Our Ref: P/37/19/PL

**Town & Country Planning Act 1990 (as amended)
Town and Country Planning (Development Management Procedure) (England) Order 2015
Application for Planning Permission**

Development Demolition of existing structures and the building of a new modern family home
Location 10 Harbour Road Pagham

Site Plan - Site Survey - EXISTING

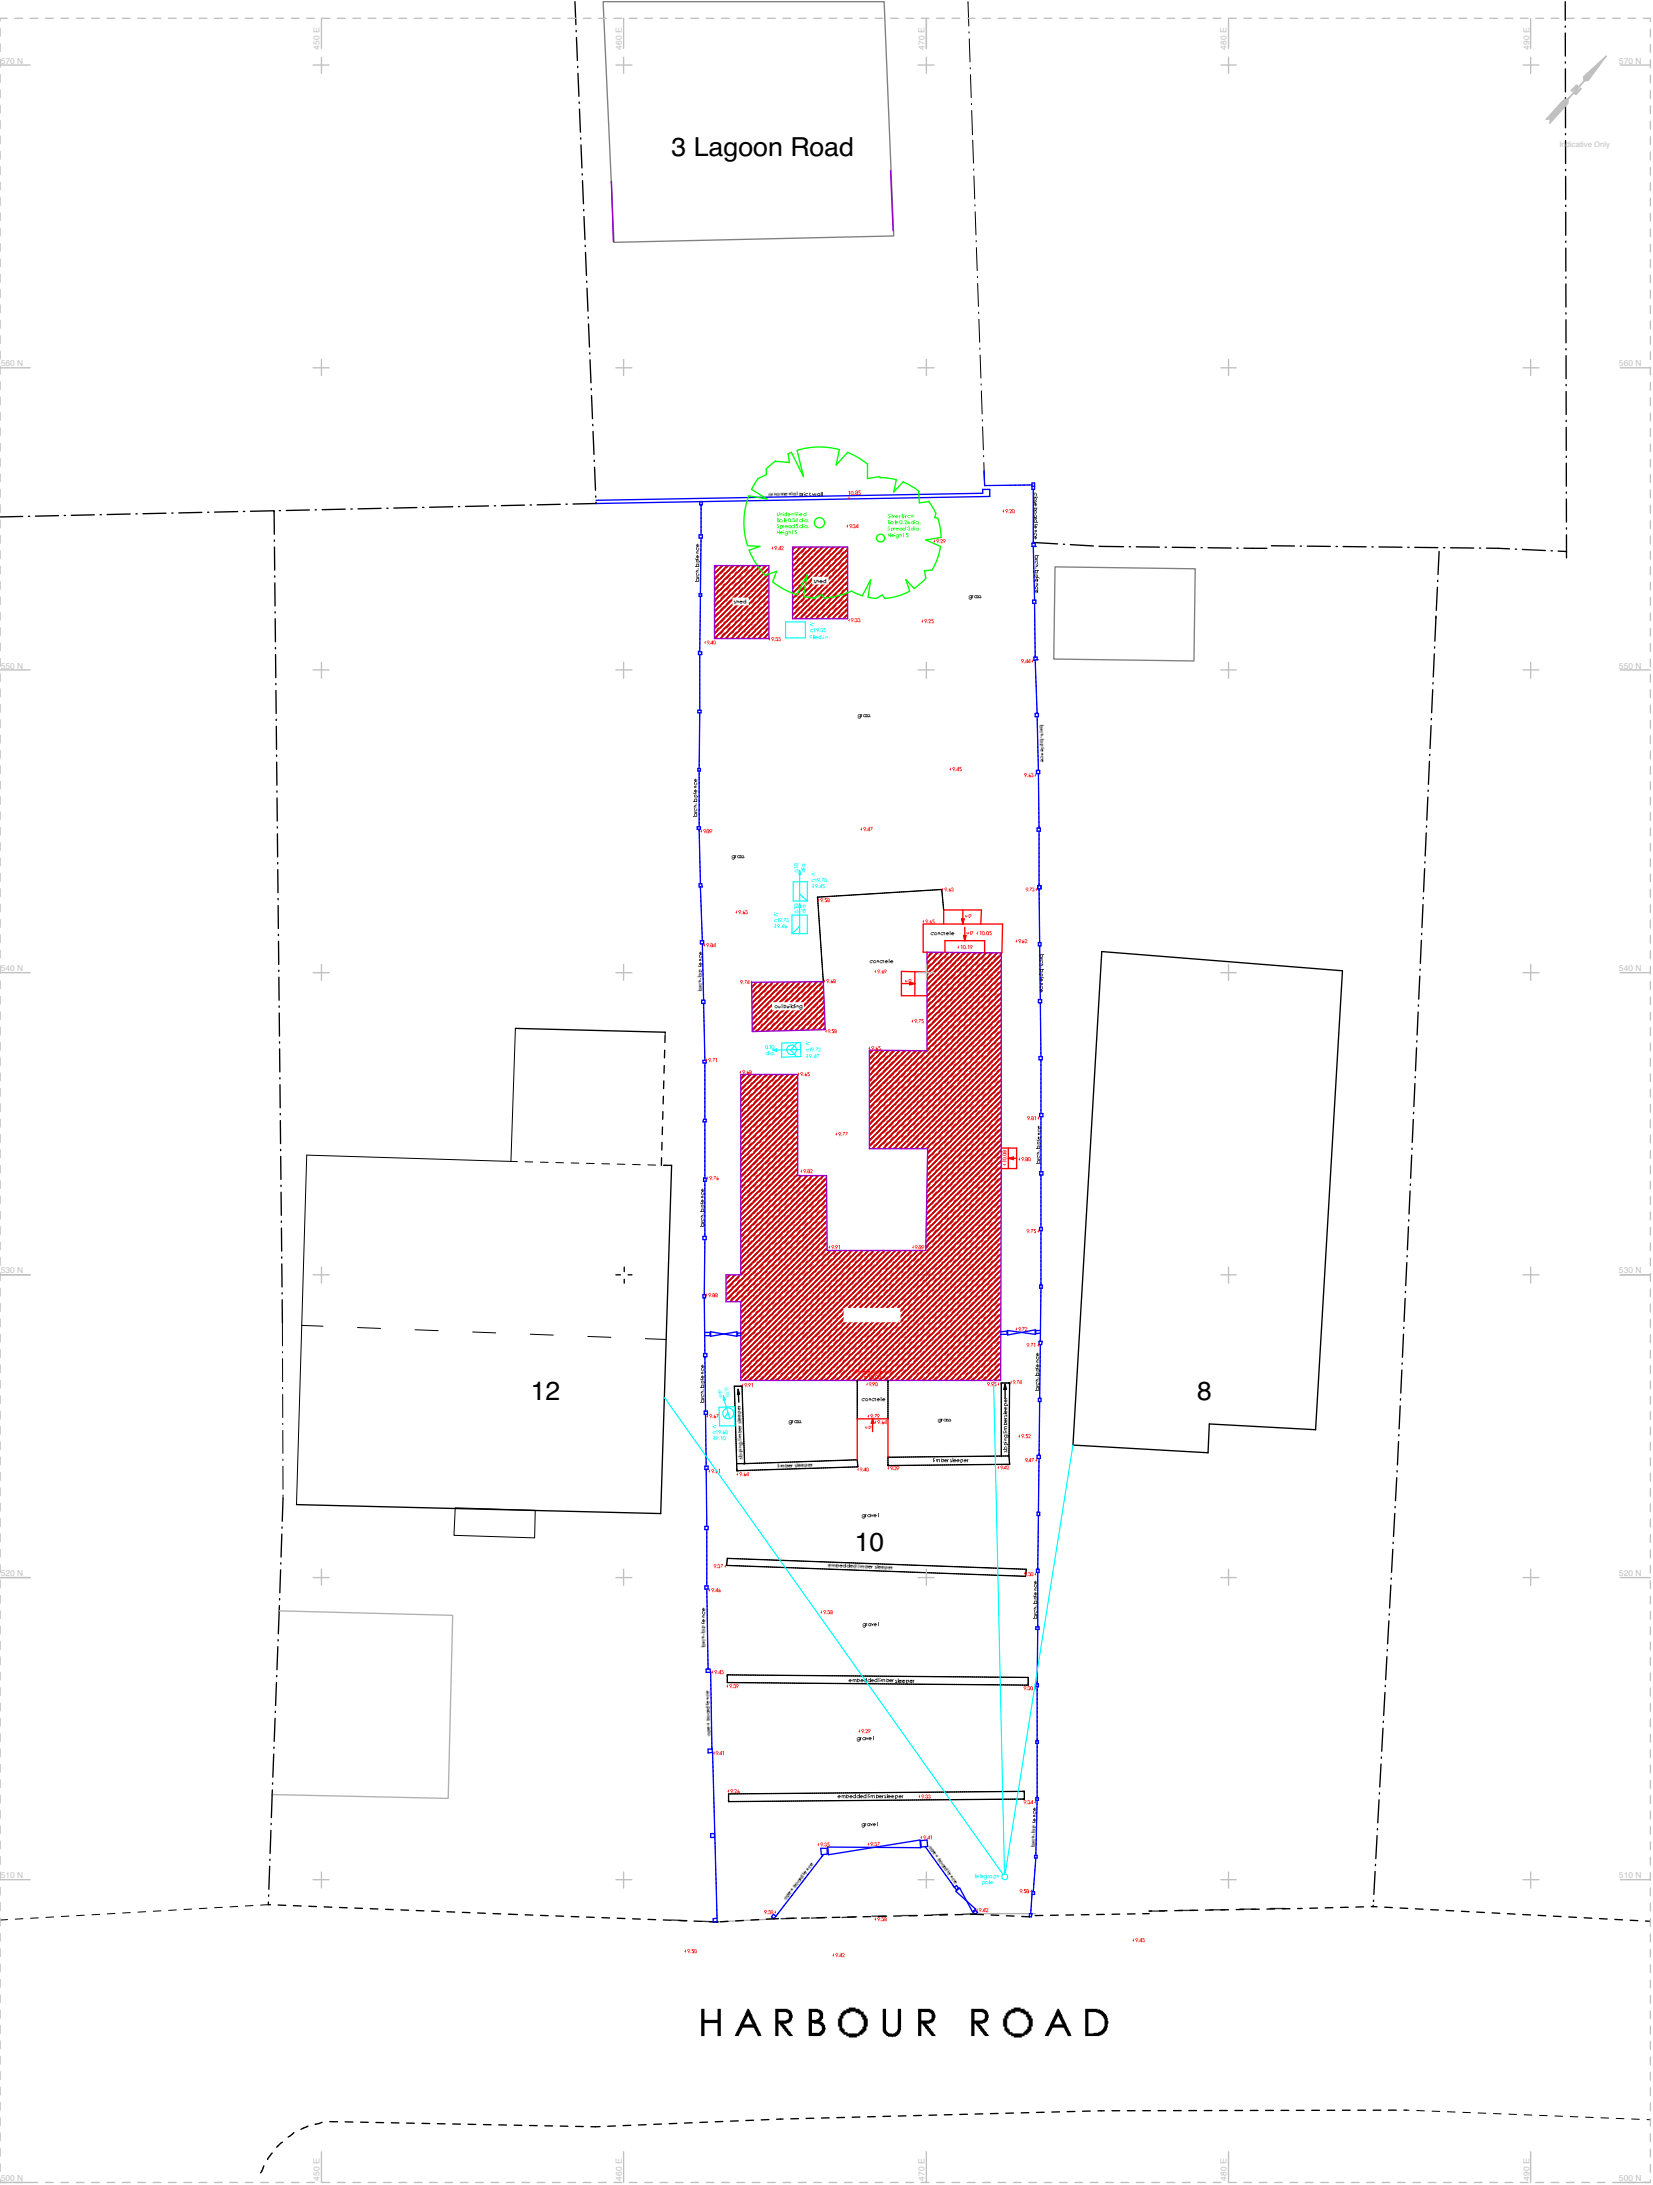
Existing Use: Please confirm the existing use of the site as the Design & Access states 2x bungalows but the existing block plan is showing 3x carriages and amend your form/plan to show this.

SHEET TITLE
Plans (Proposed)

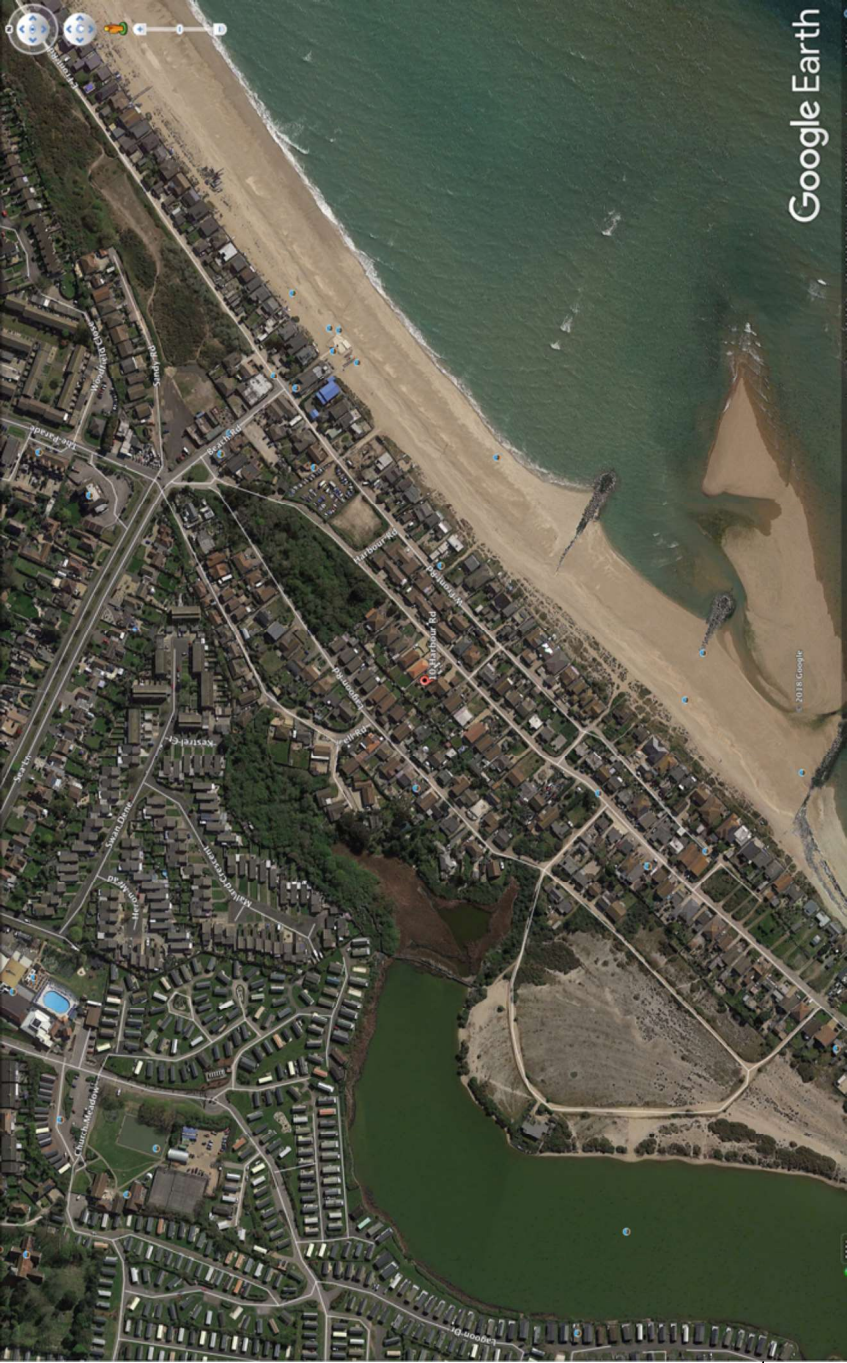
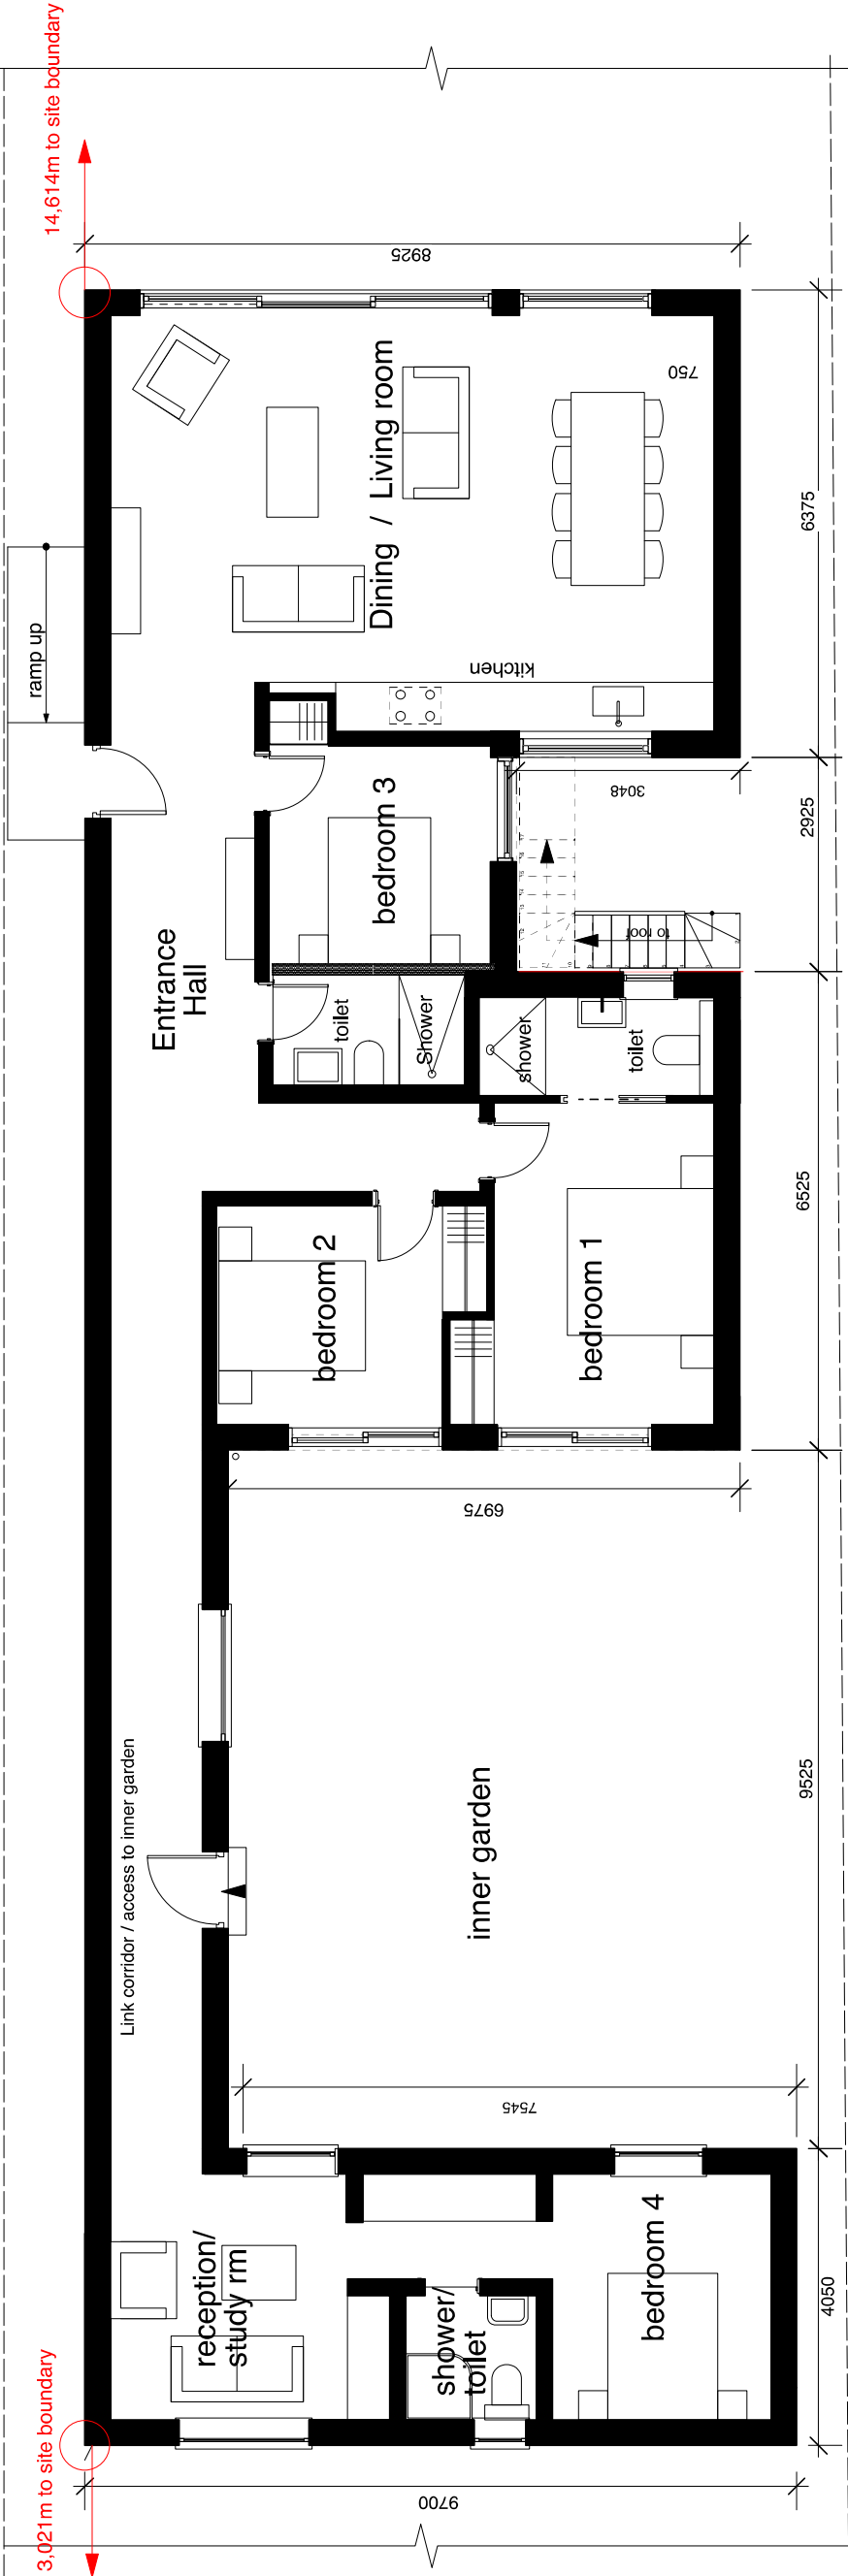
Please submit 1 electronic or 3 paper copies of a proposed block/site plan which includes all dimensions from the new dwelling to all site boundaries.
